Tel: 01903 737756
Email: planning@arun.gov.uk
www.arun.gov.uk/planning
Please ask for: Ms Ella Summerfield
Email: ella.summerfield@terraquest.co.uk
Telephone: 0121 2341390
Our Ref: CM/21/26/L
Your Ref:
Date: 23rd July 2026

Development: Replacement of existing windows (7 no. in total) plus 1 no. exterior door with identical style.

Location: Kents Farm House Brookpit Lane Climping BN17 5QU

ELEVATION C-C

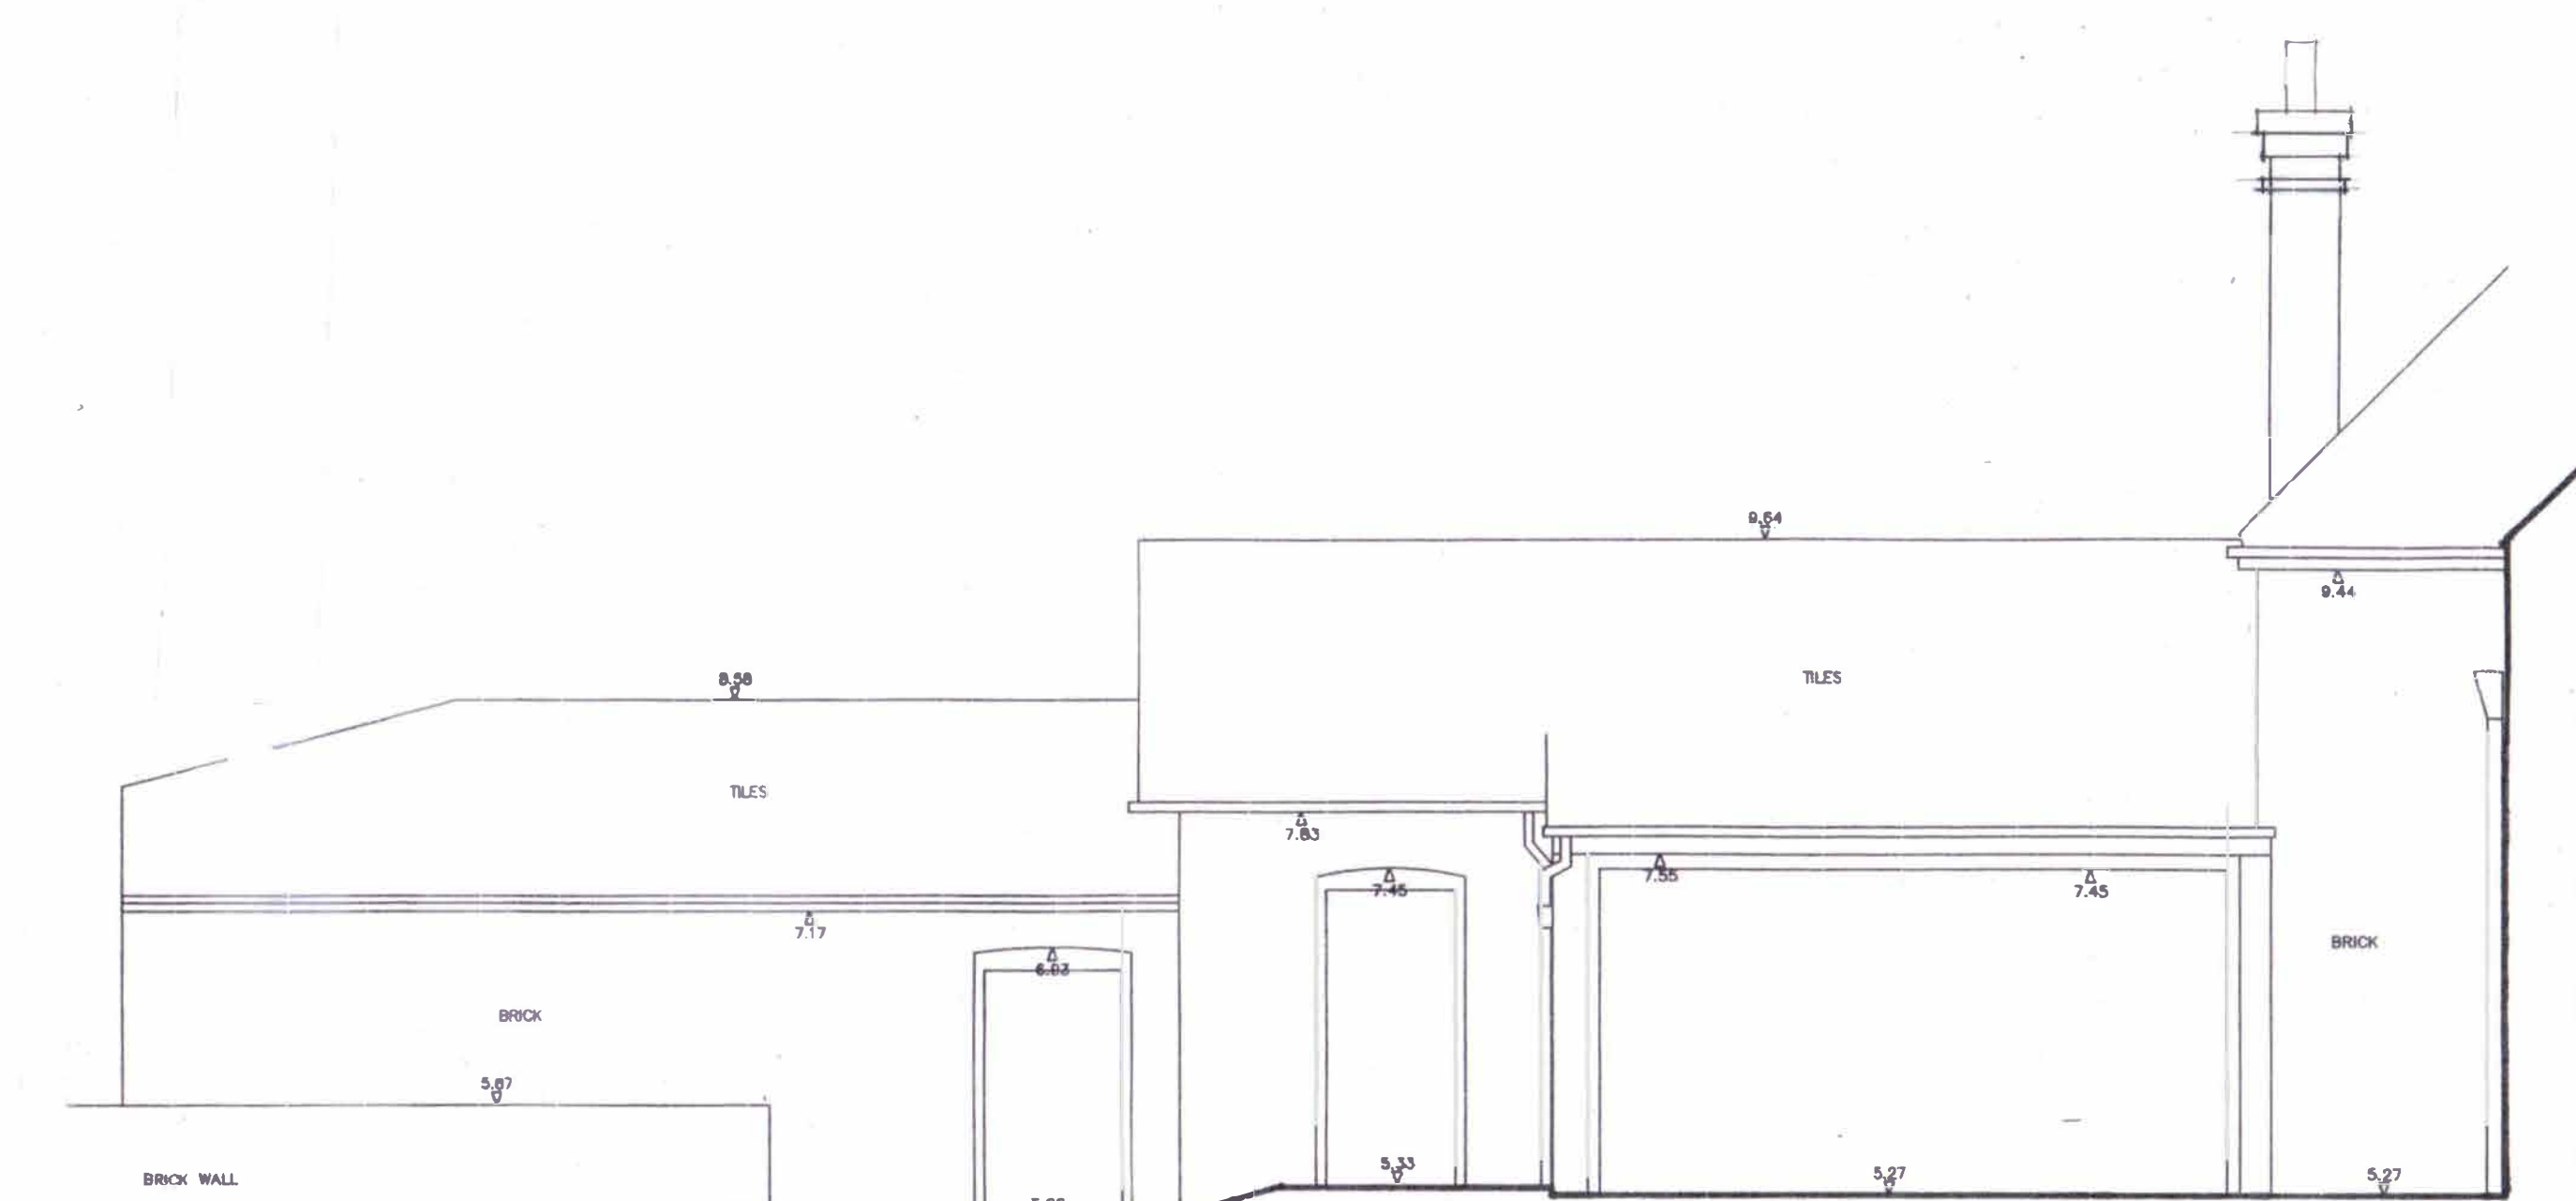
The proposed elevation plan scale bar appears to be inaccurate to the provided scale, please review.

When there are two scales provided the plan must clearly show which scale belongs to which drawing.

Please upload a scanned version of the proposed elevation plans in pdf format- The Proposed elevation plan provided is blurry.

NORTH WEST

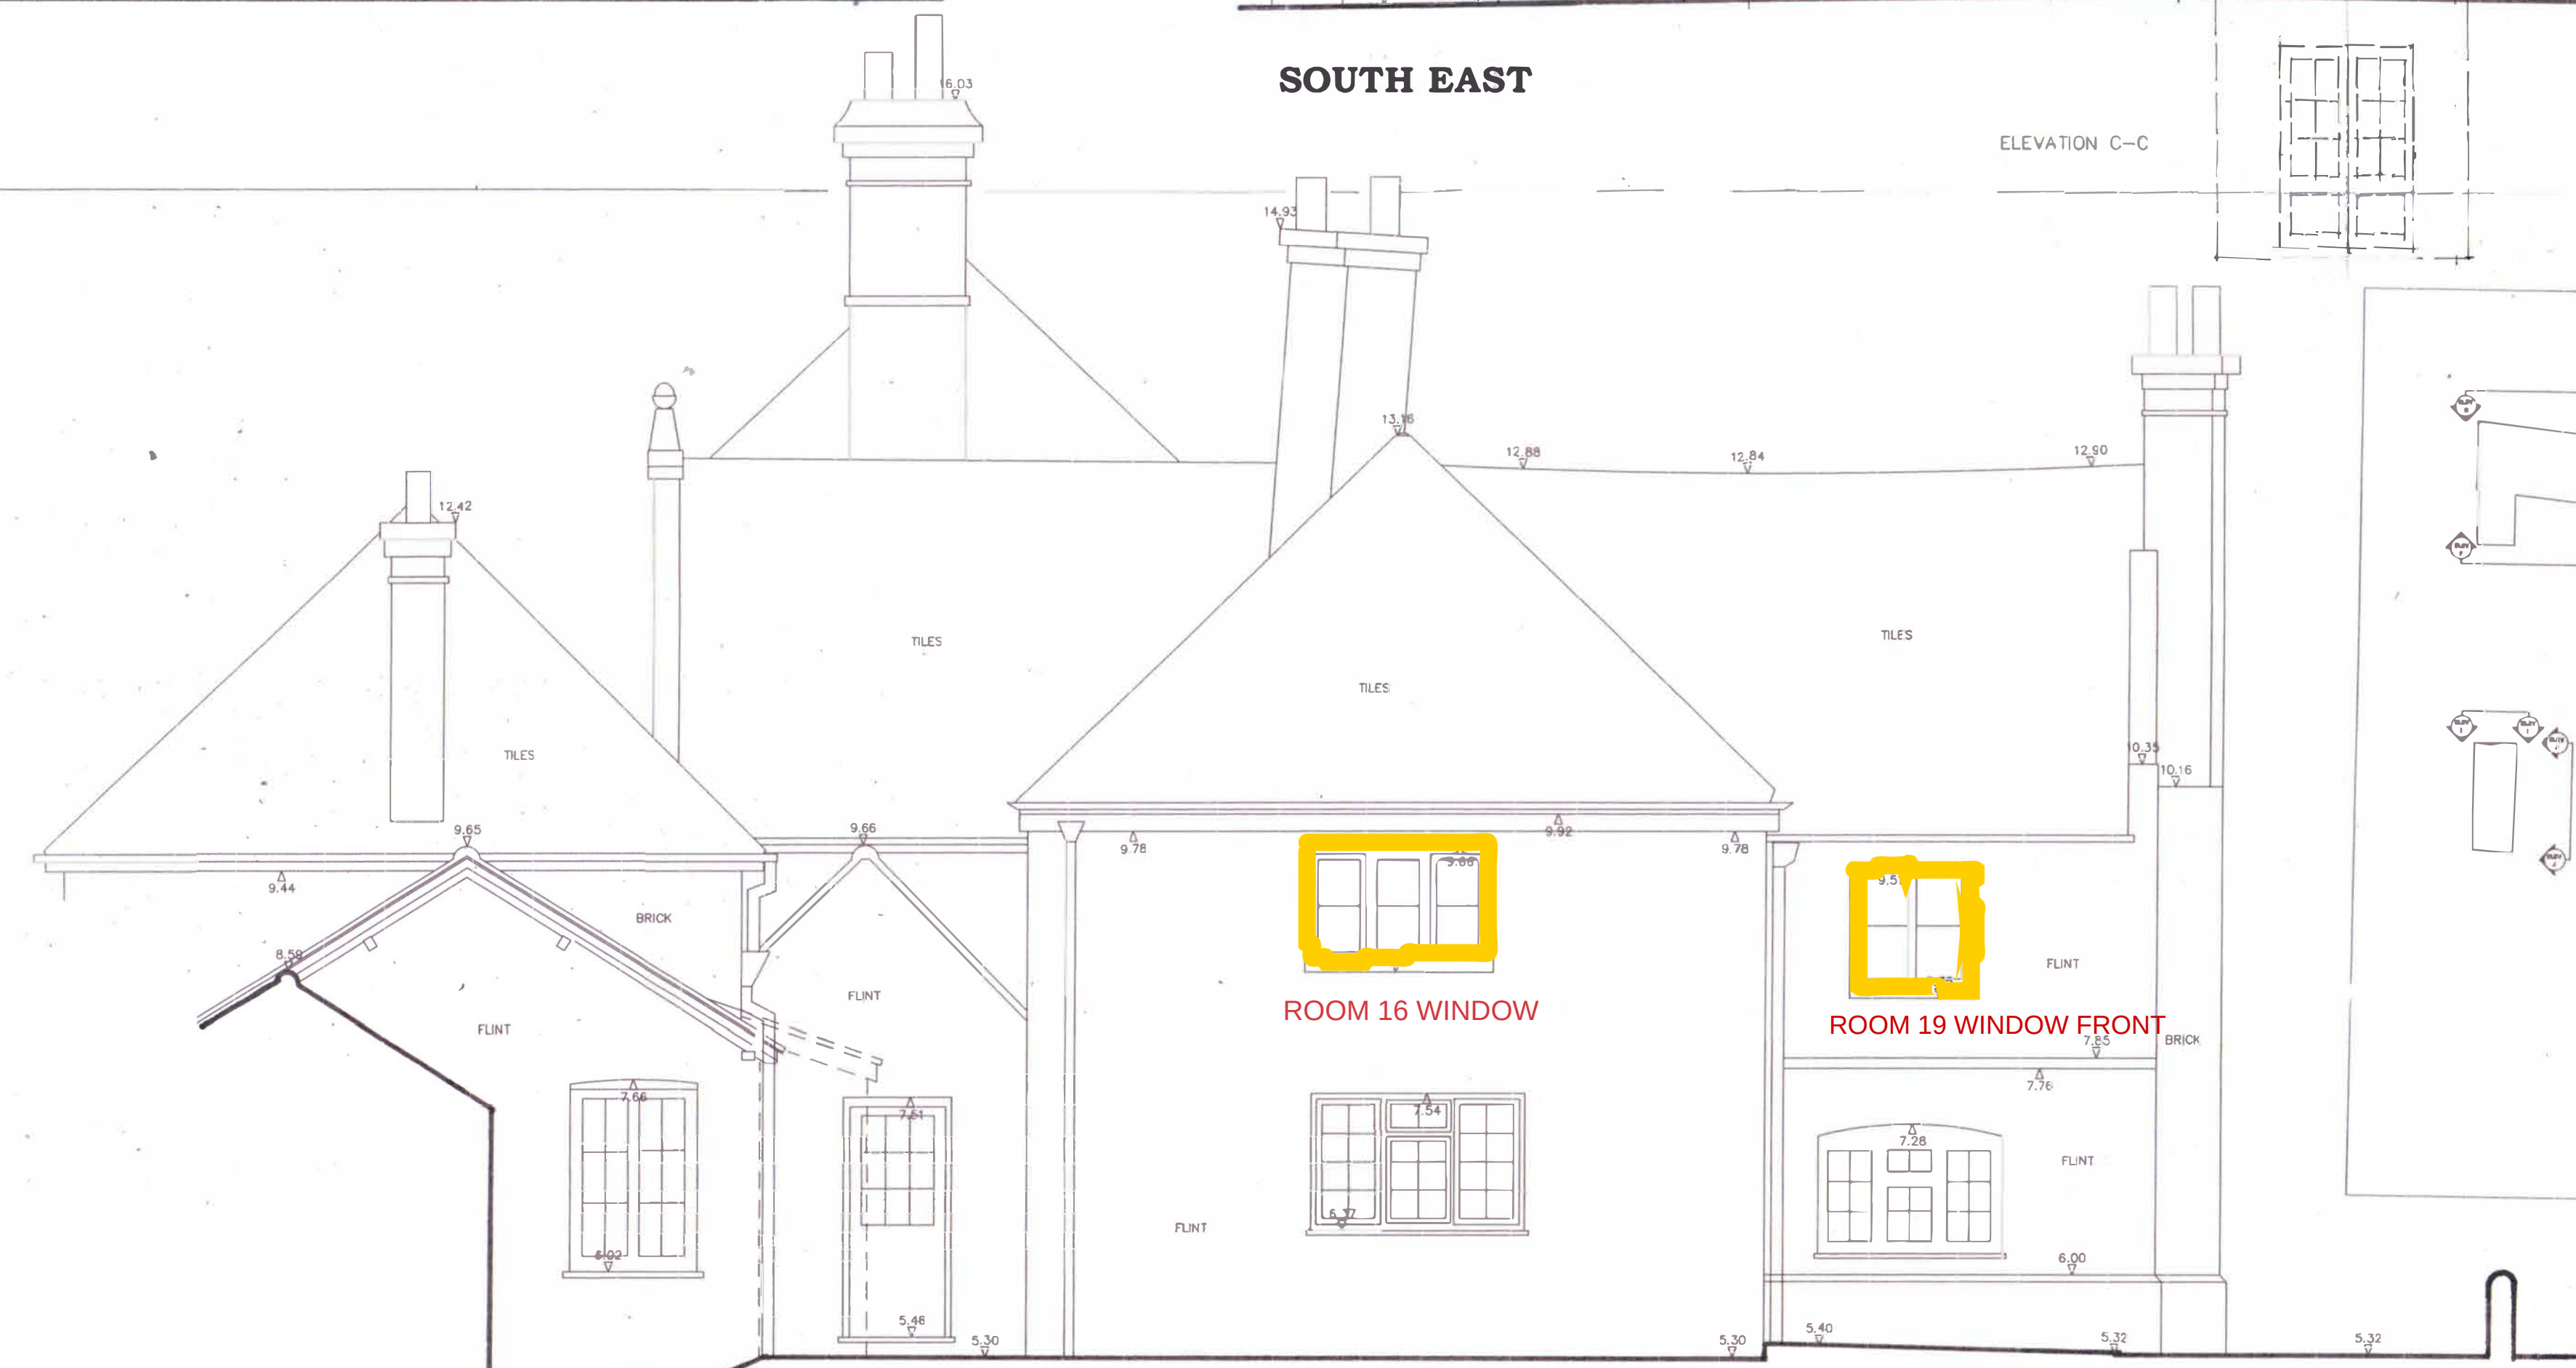
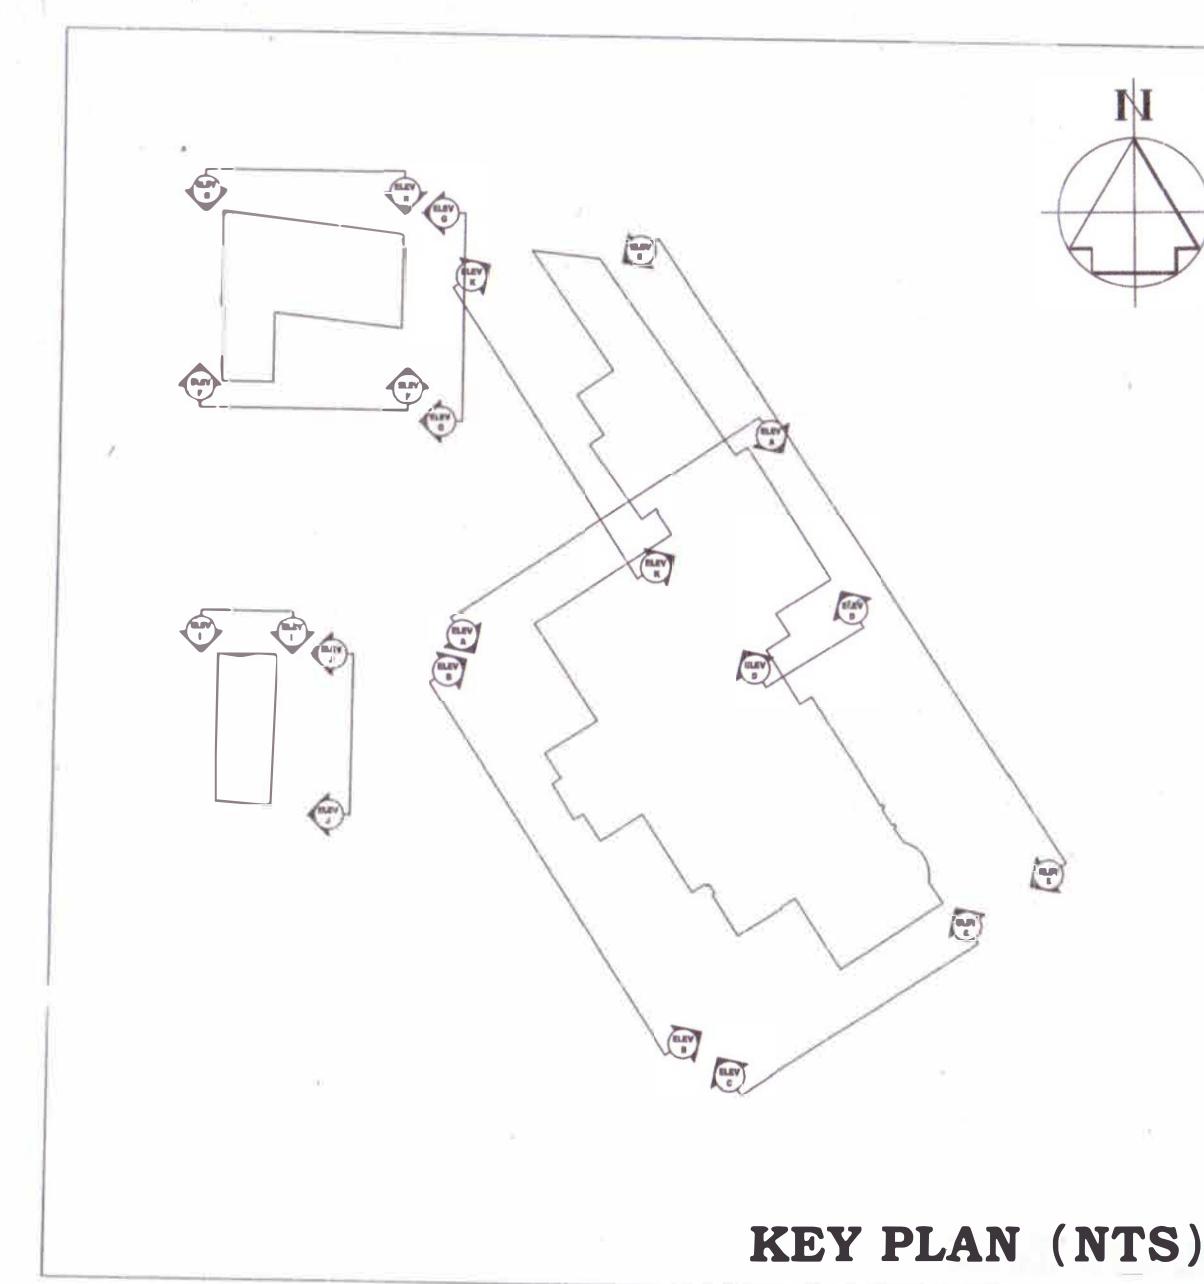
On the proposed elevation plan, the north west elevation has a window highlighted which is not labelled or mentioned on the schedule of materials and finishes. Please review and amend accordingly.
